**From:** [REDACTED]  
**To:** [Norfolk Boreas](#)  
**Subject:** Norfolk Boreas Project EN10087. Comments on the Applicant's Comments on Deadline 10 Submissions Plus  
**Date:** 27 July 2020 17:59:00

**SCENARIO 1**  
**Figure: 29.33d**  
**Viewpoint 11: Hale Road, East of Holme Hale Hall**

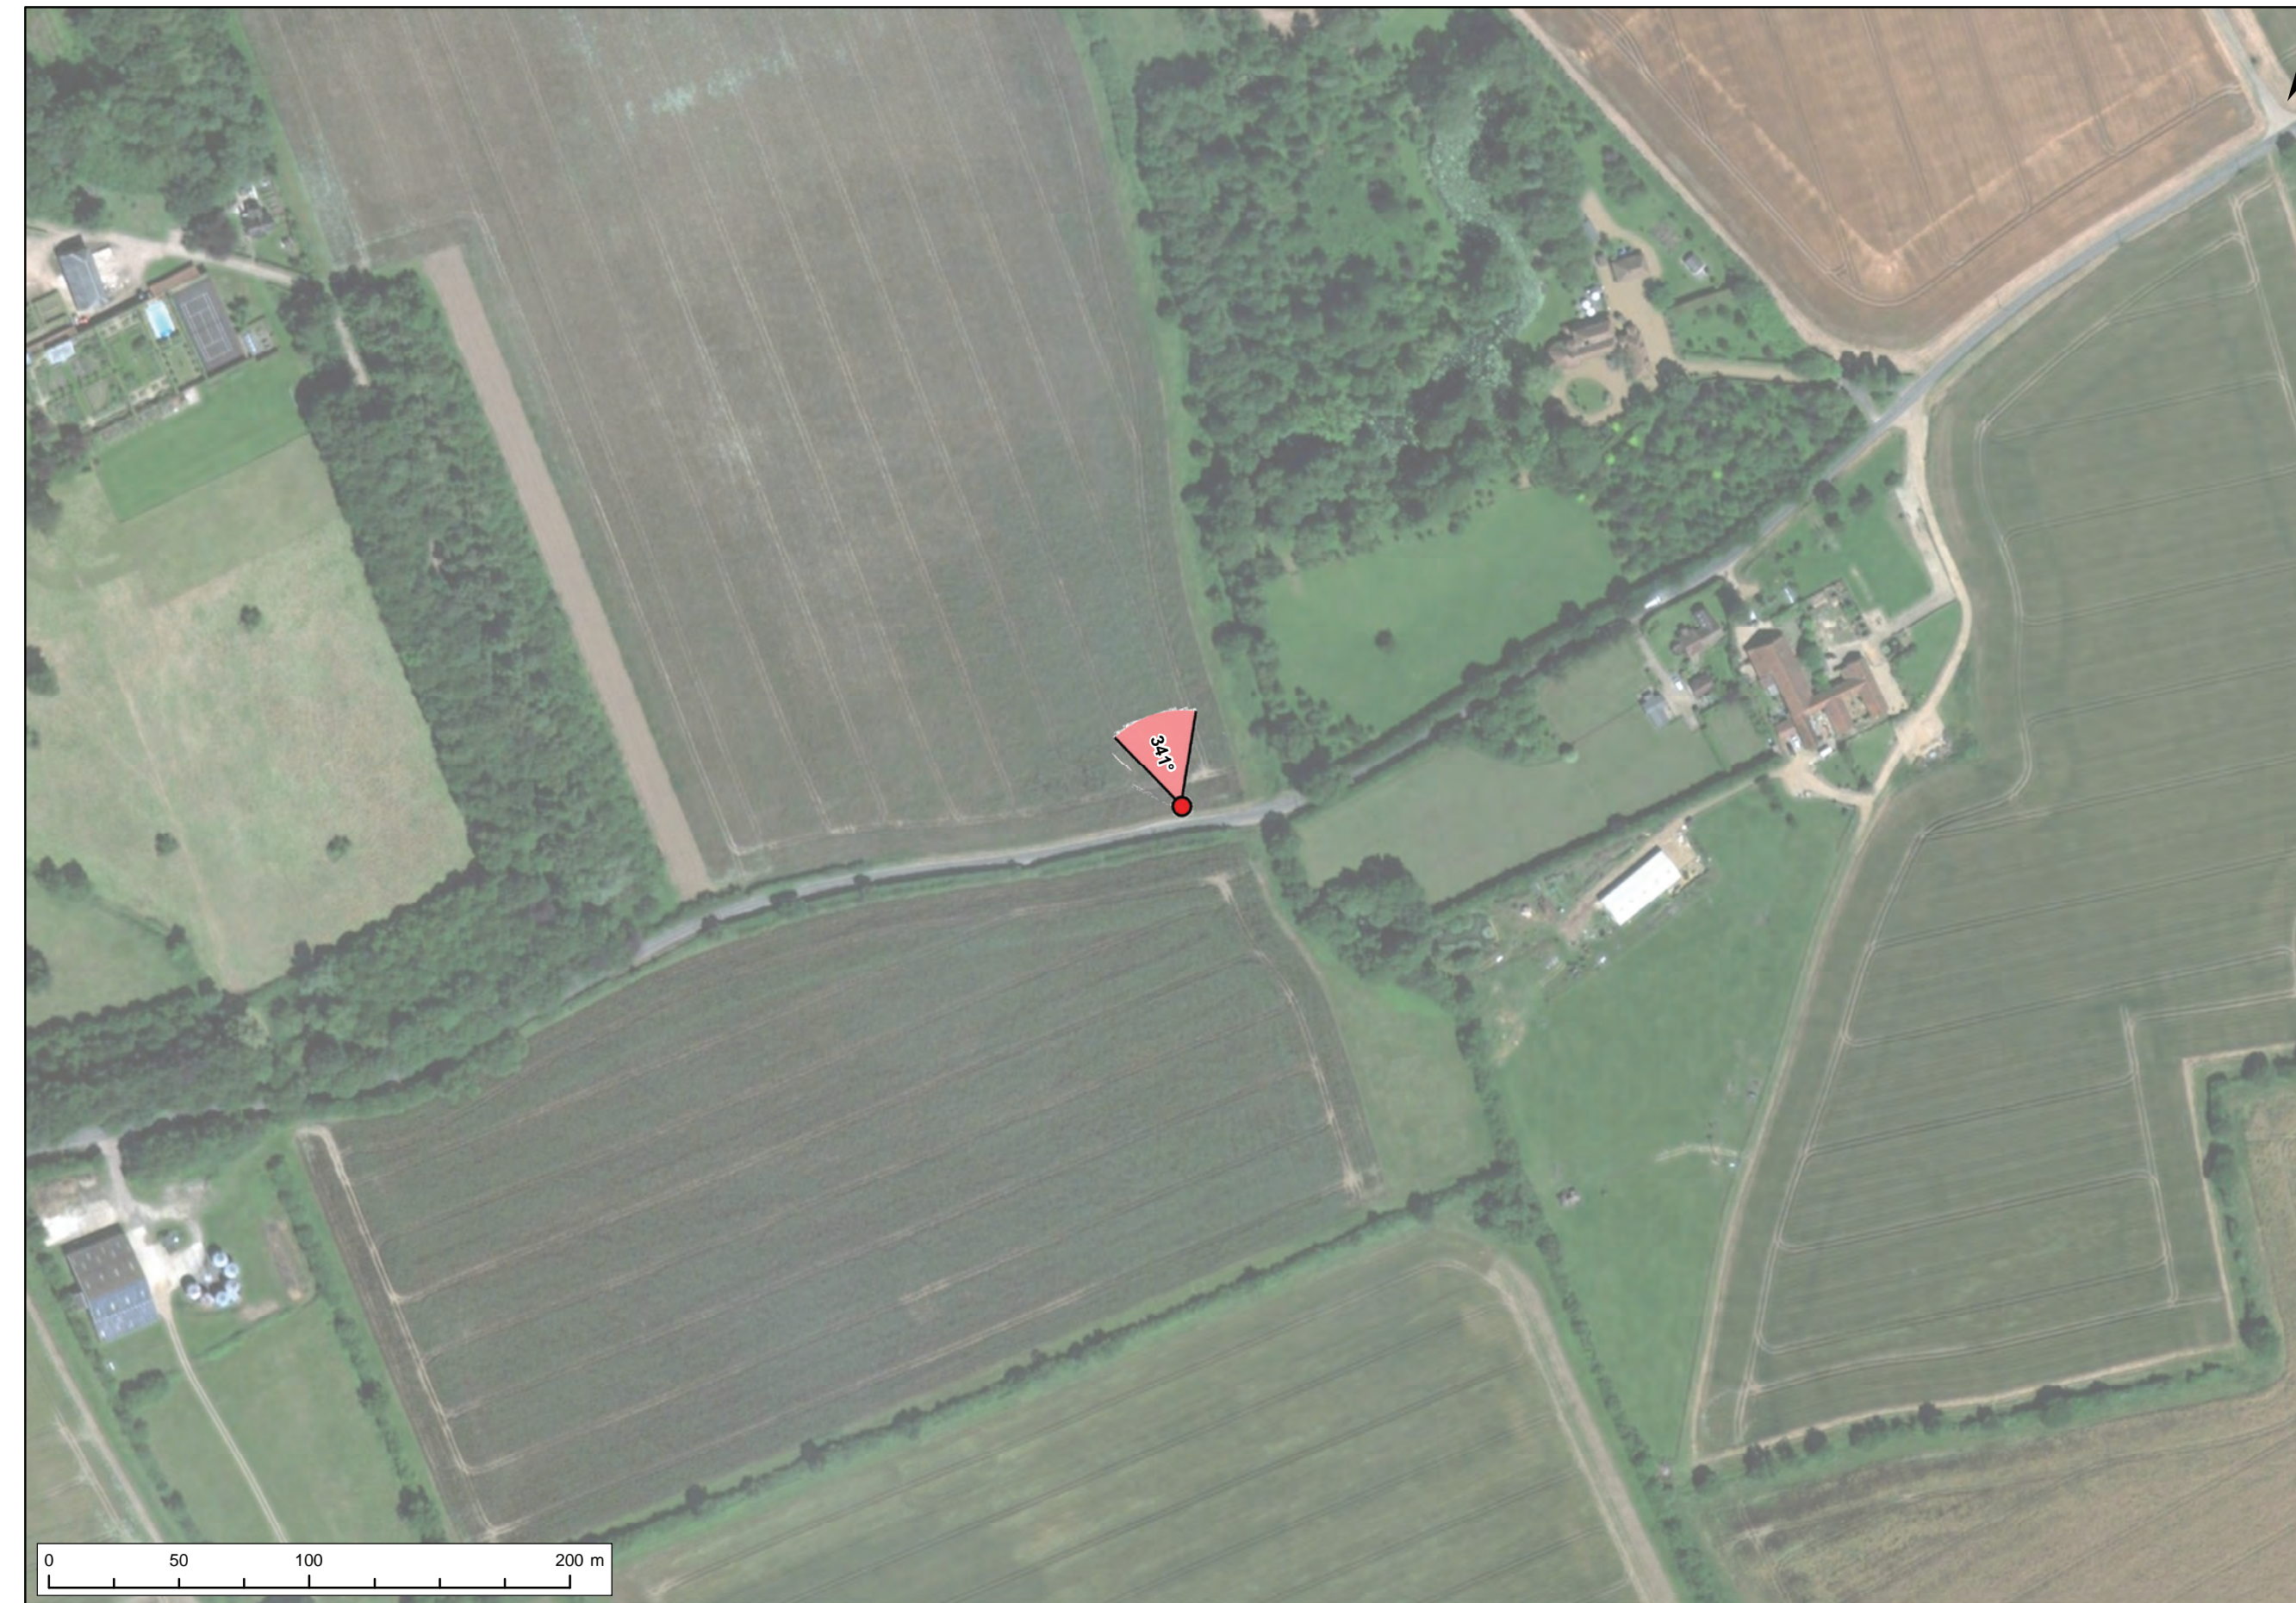
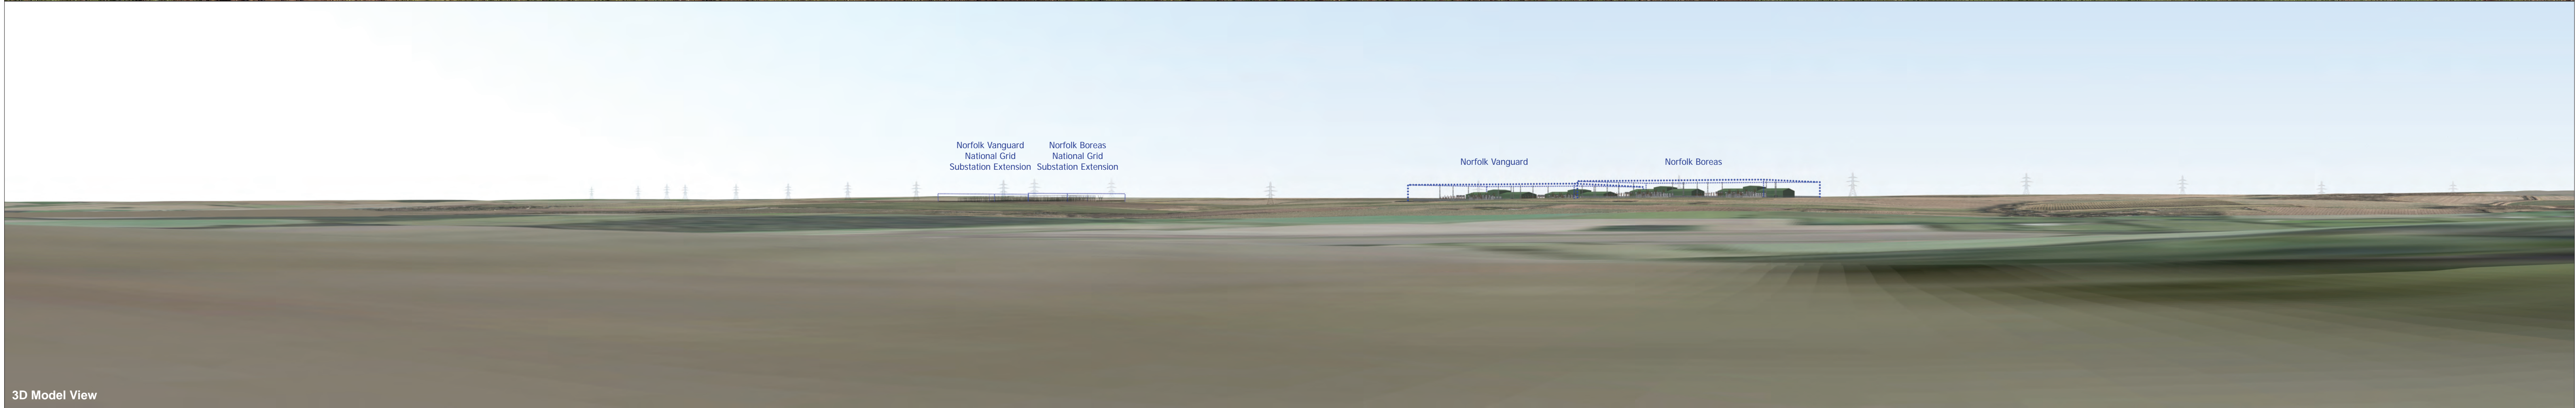
This I find misleading: 1. The blue dotted lines look like an indication of the extremities of the site footprint, not the maximum possible size of the infrastructure.  
2. The images of the converter halls may be an underestimation.  
3. The images of the converter halls are an underestimation, as on close inspection the front facade of the halls are set on the back boundary line, meaning the halls are being shown how they would look, built off site, behind the furthest boundary.

This is disappointing when the applicant has explained that they position the halls in the visualisations with great care and attention using landmarks, (but not as far as we know, using vectors and vertices from OS Terrain 5 DTM) and results in a degree of inaccuracy, on its own, making the visualisations less than reliable and useful to gauge the required mitigation.

The applicant also suggests that the 2D diagrams do not represent the effect of perspective and the photo montages do. Perspective, distance, visual angle, field of view, depth of field etc. cannot alter how much of the halls are hidden behind landforms or mitigating trees. A scale 2D diagram including all factors eg. ground level and contours, distances, mitigation and the object in question, with a straight line of view, demonstrates how much of the halls would be in view very well.

The use of a Rochdale Envelope at Necton with regard to the ground level of the converter halls, and whether substantial bunding is to be used in the mitigation, is inappropriate as adjacent land is rural, agricultural, not commercial, industrial, creating a situation much more sensitive to variations in landscape and visual effects. In fact the amount of variance allowed by a Rochdale Envelope and shown in the applicants visualisations, which show an image of minimal possible size and presence of the converter halls, and demonstrates a maximum possible size and presence with a dotted blue line, is again inappropriate to make a visualisation on which mitigation is planned. Notwithstanding the halls are shown behind the site's far boundary.

Basing visual impacts, and mitigation effectiveness on visualisations that are underestimations, and adding dotted lines to show over estimations, is not working to the aforementioned requirements. I suggest not specifying a ground level, and the use of bunding also falls short of the Rochdale Envelope requirements to fully assess the project.
